# Meadowlake Industrial Park Filing No. 1 Preliminary Plan Traffic Impact Study

FEBRUARY 1, 2024

# LSC Responses to TIS Redline Comments

Figure 7  
**2025 Total Traffic,  
 Lane Geometry, Traffic  
 Control, and Level of Service**  
 Meadowlake Industrial Park Filing No. 1 Preliminary Plan (LSC #S234040)

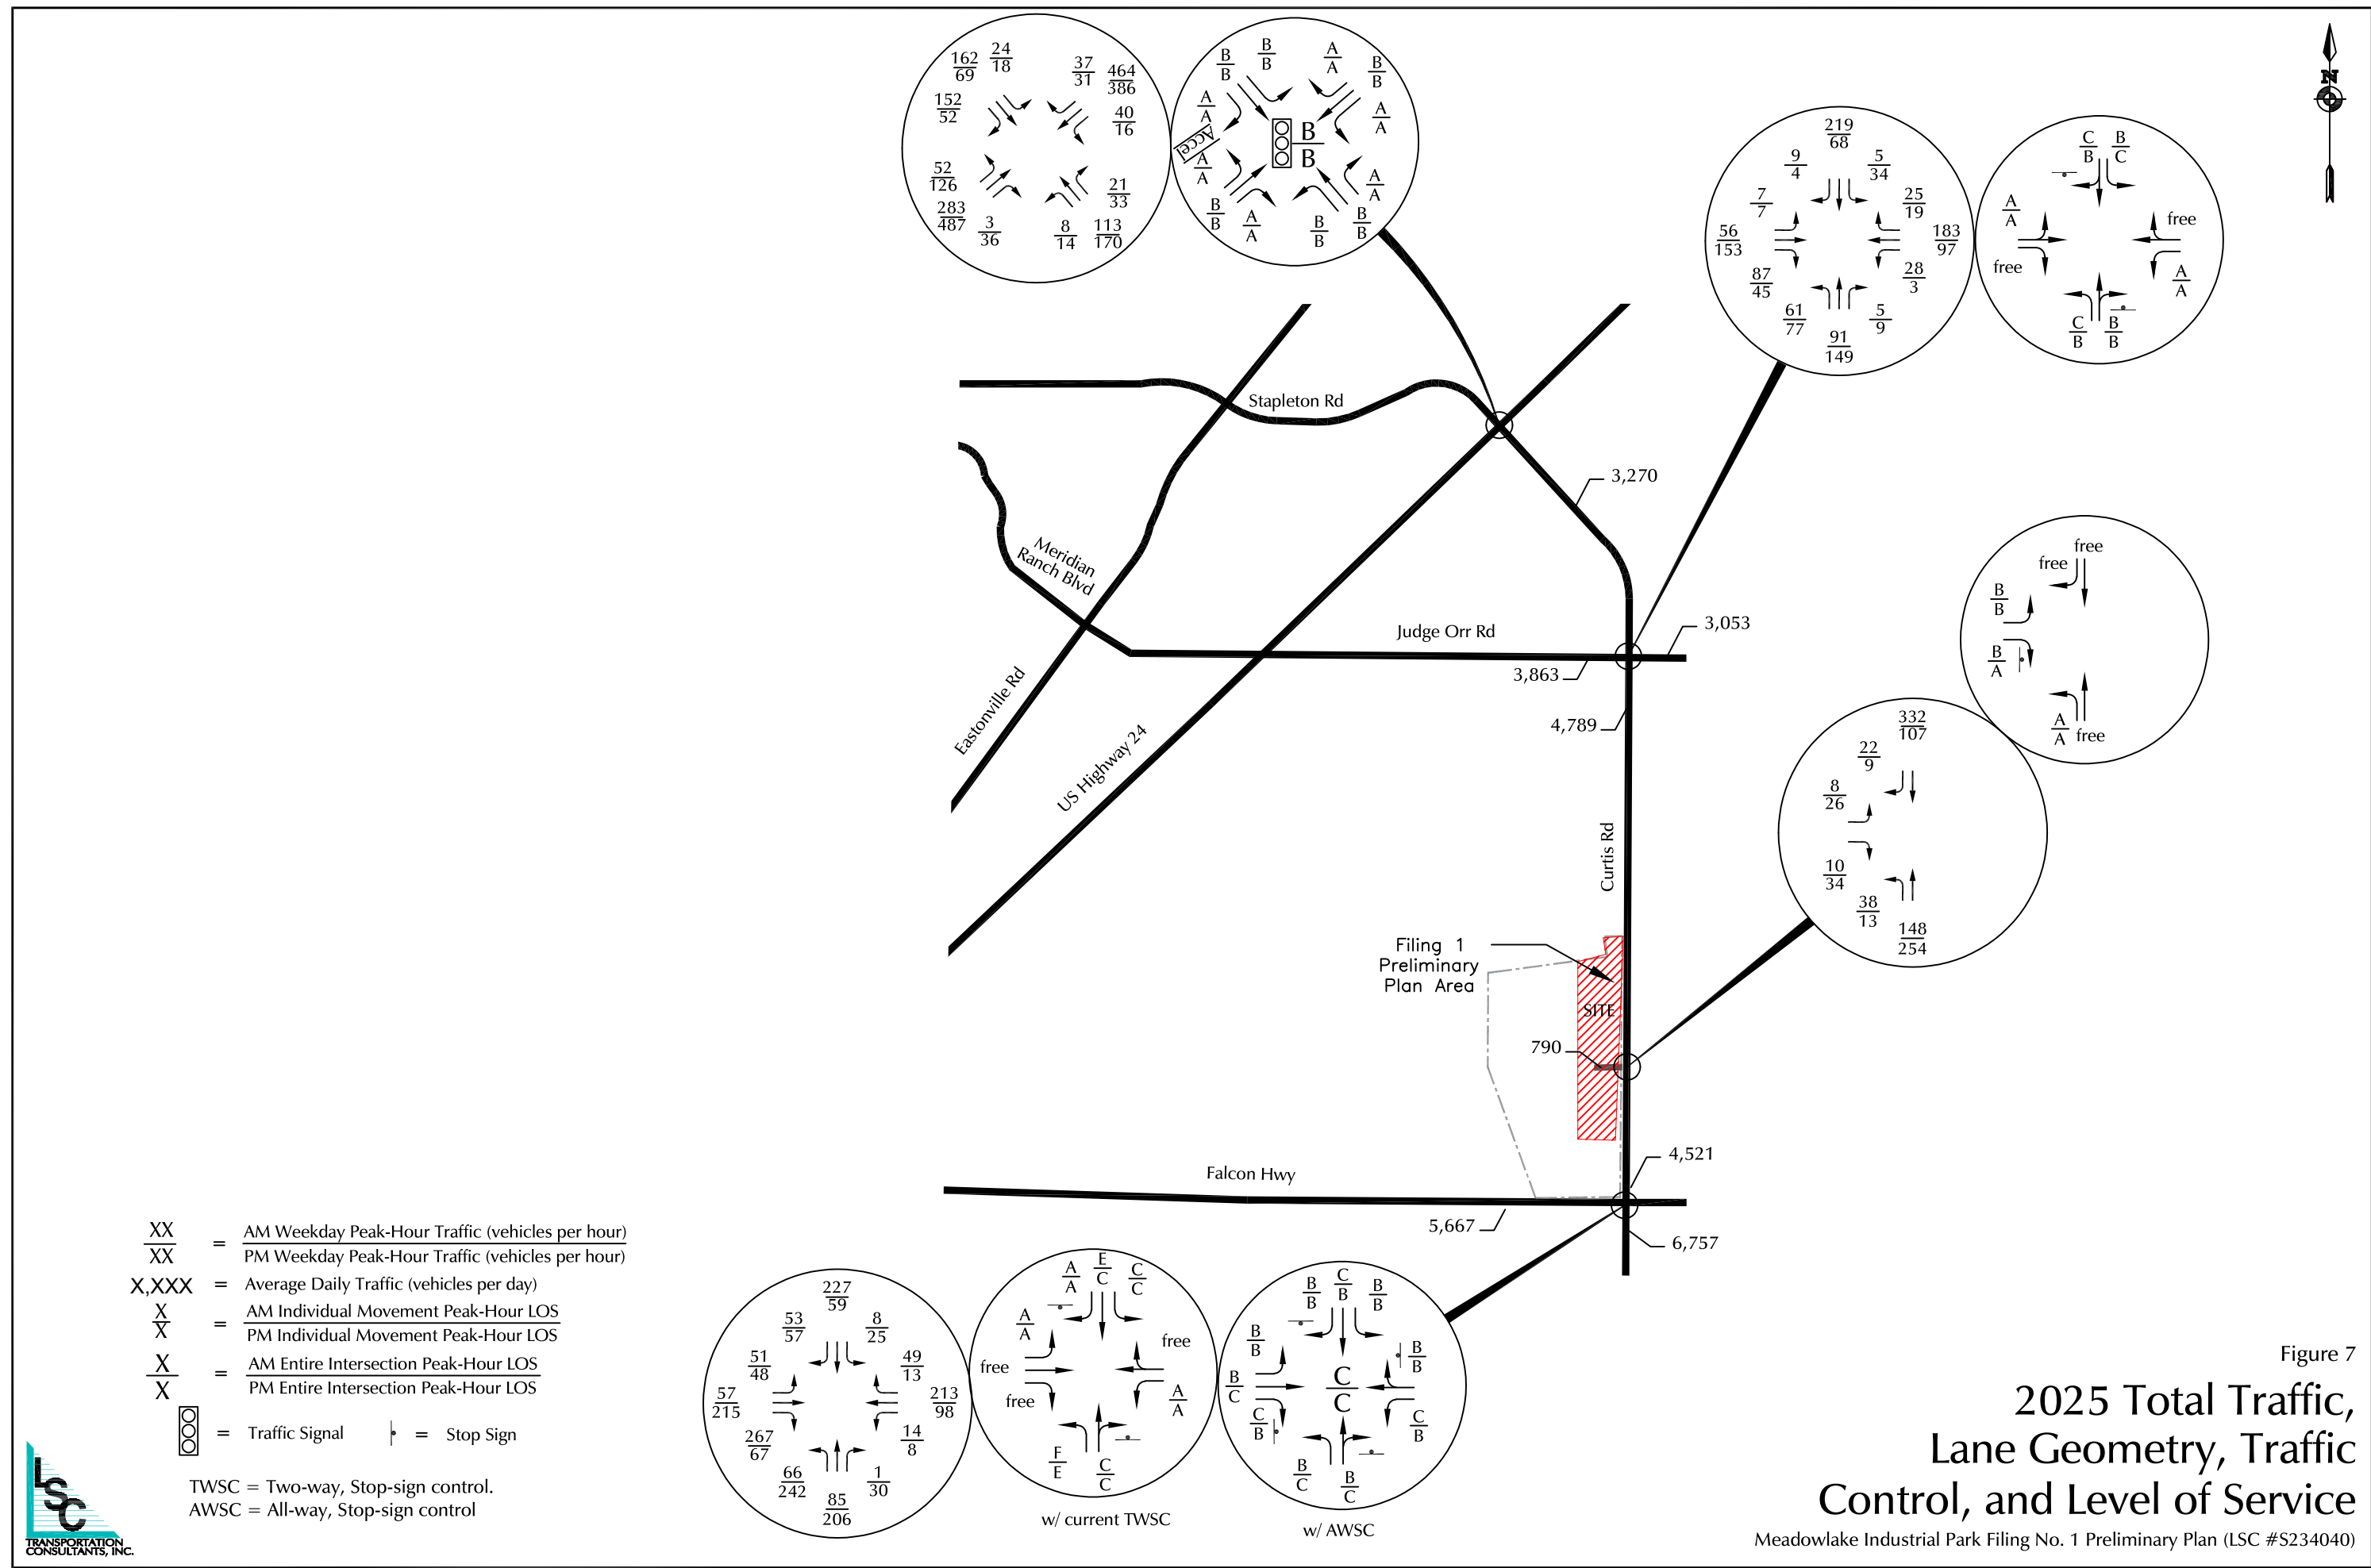
please clearly state whether this is needed due to this preliminary plan developments traffic which it appears it will be per the volume provided in the figure.

👉 Author: jchodsdon Subject: Sticky Note Date: 11/15/2024 3:06:18 PM

LSC Response: This section has been revised in the updated report. Revisions/updates have been made to the auxiliary turn-lane table and the improvements table as well.
